SH24G/Stapleton Rd.
El Paso County

RE: Waterbury Filings No. 1 - SF237

The Master Development Drainage Plan & FINAL Drainage Report for Waterbury Filings No. 1 & 2 dated February 2023 and the Grading, Erosion & Sediment Control Plan for Waterbury Filings No. 1 & 2 dated December 20, 2022 have been reviewed by a CDOT Hydraulics Engineer. Their comments follow:

POND 3
SCALE: 1"=30'

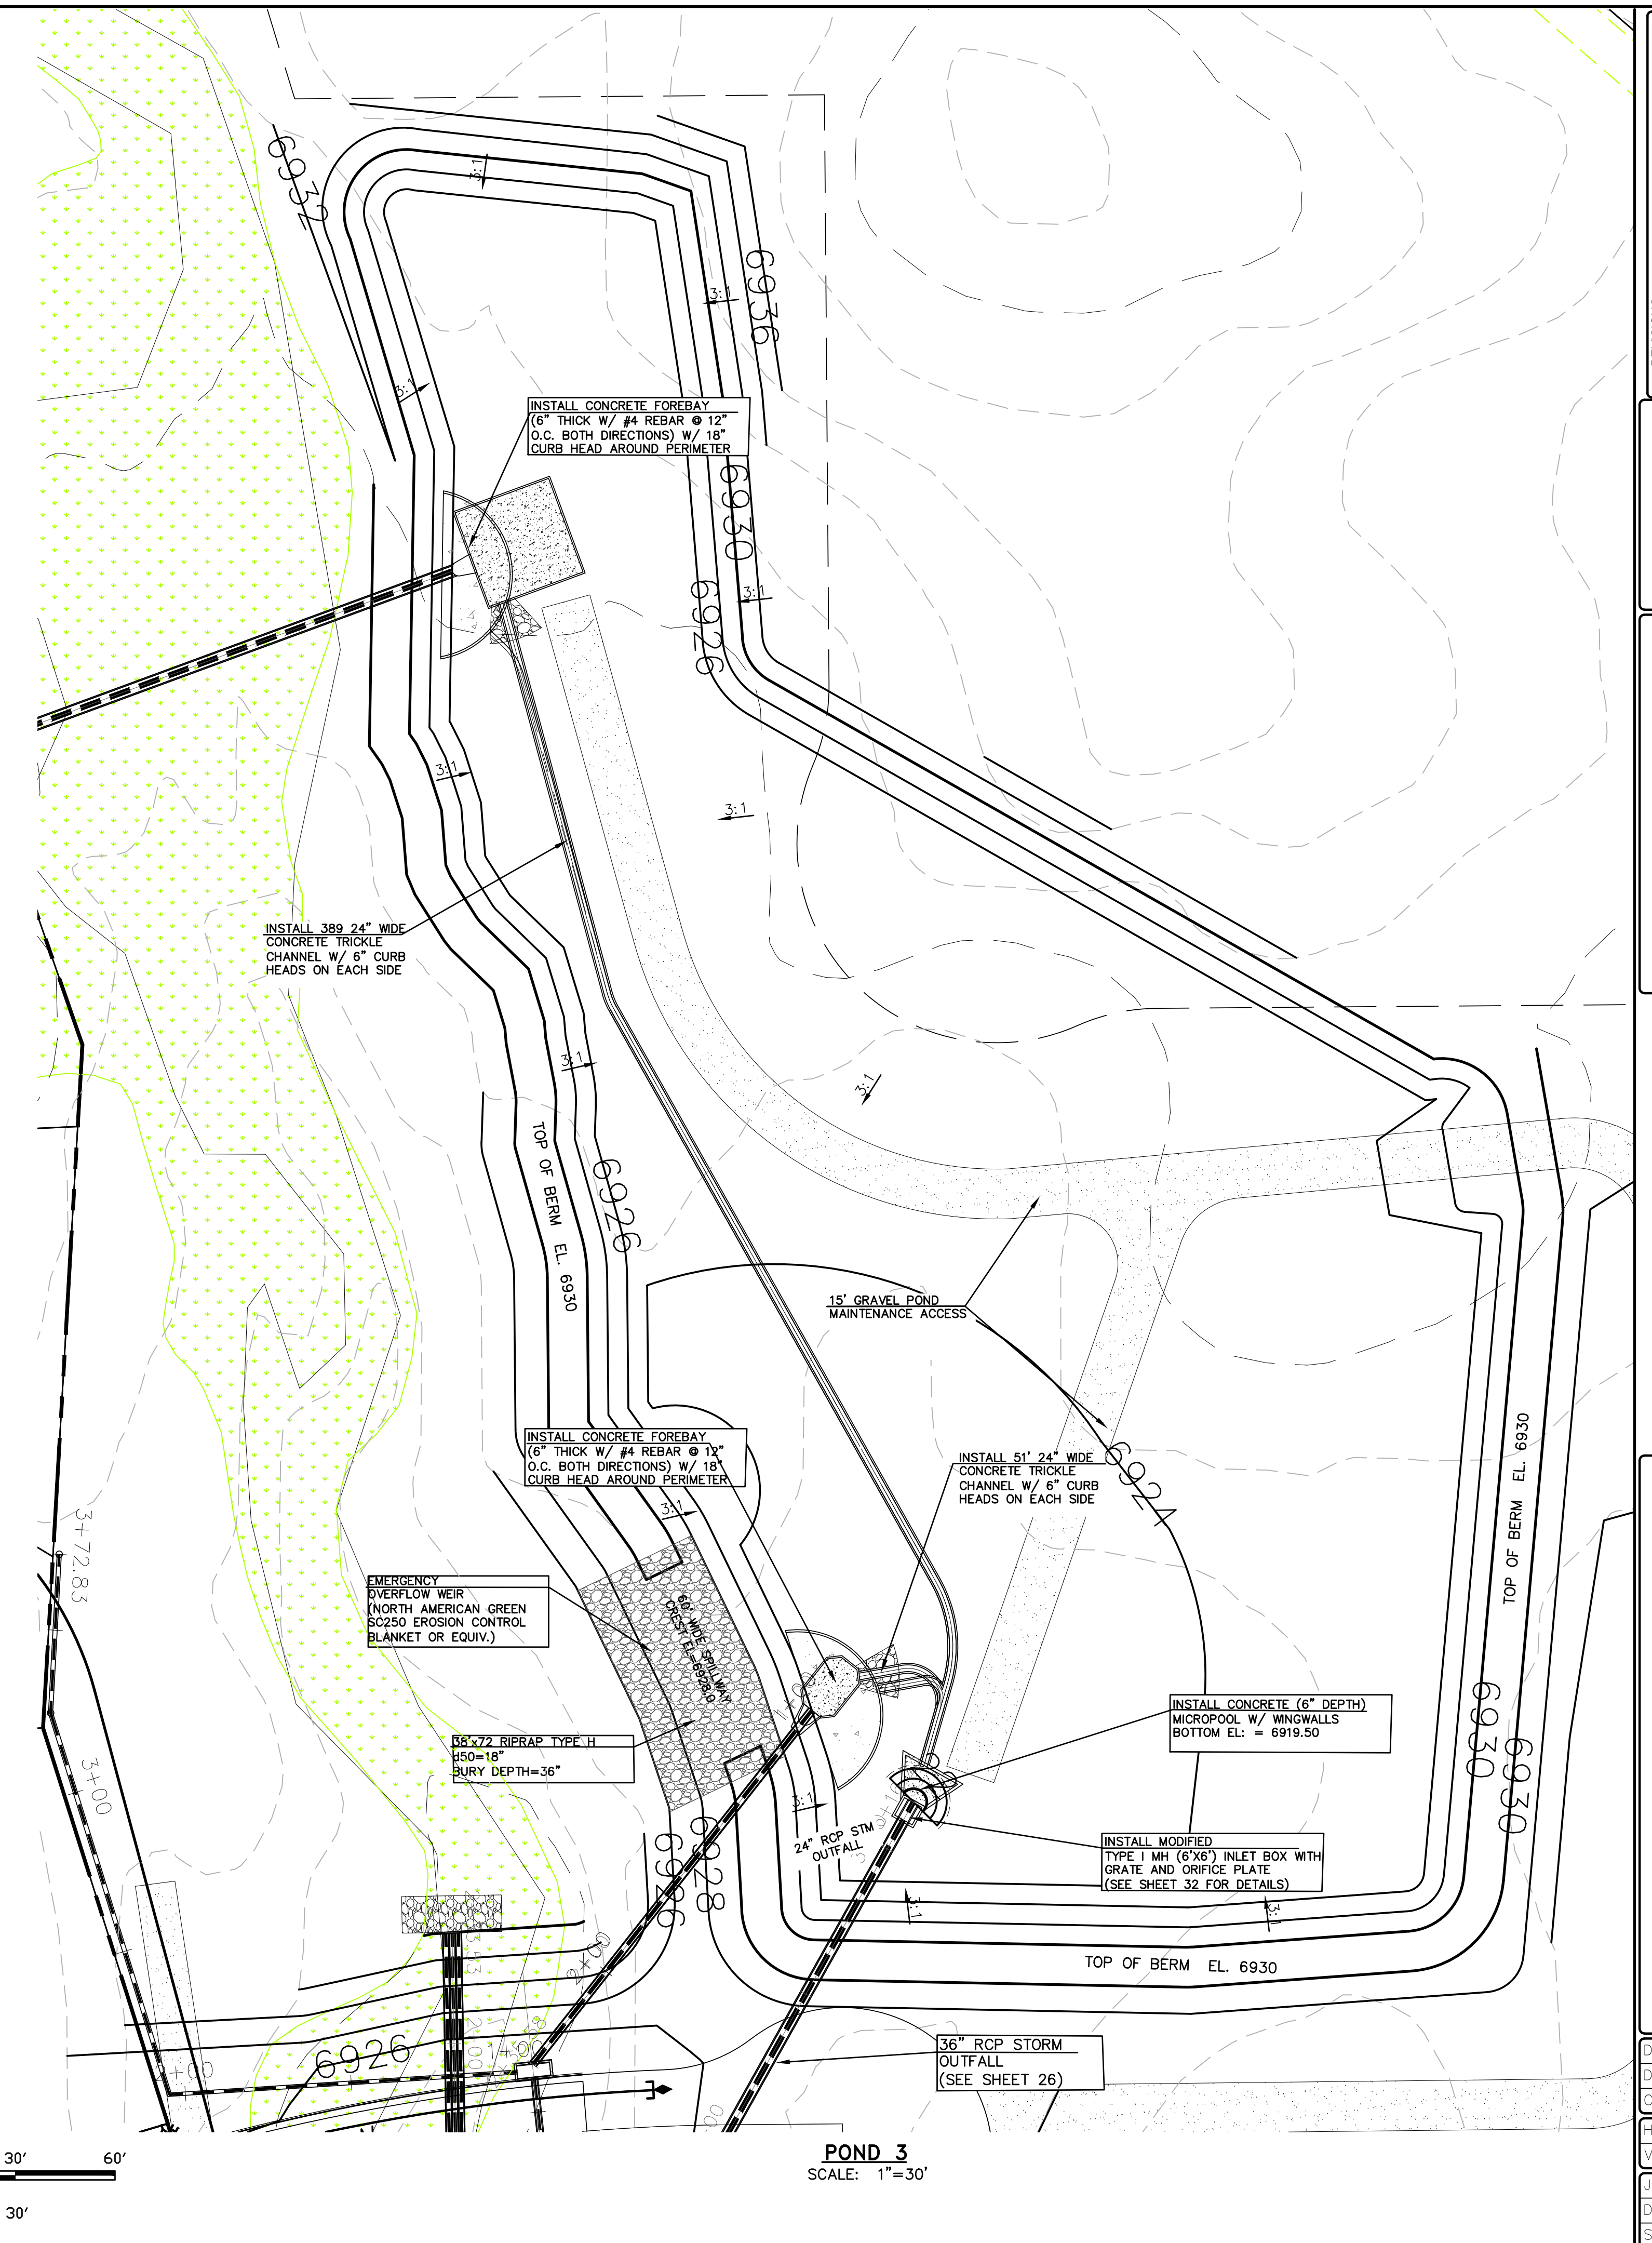
- Drainage Point 29 indicates that 4 offsite basins will discharge to FSD Pond 3. The total contributing area is over 82 acres. This is included in the UD BMP sheets, however the basin maps and basin summary tables suggest that only 24 acres are tributary to FSD Pond 3. If the intent that the pond is sized for the future, but only the proposed conditions are included in the report, it is not clear. Please resolve discrepancy.
- Verify inputs on the Detention Basin Outlet Structure Design sheets match the construction plans.
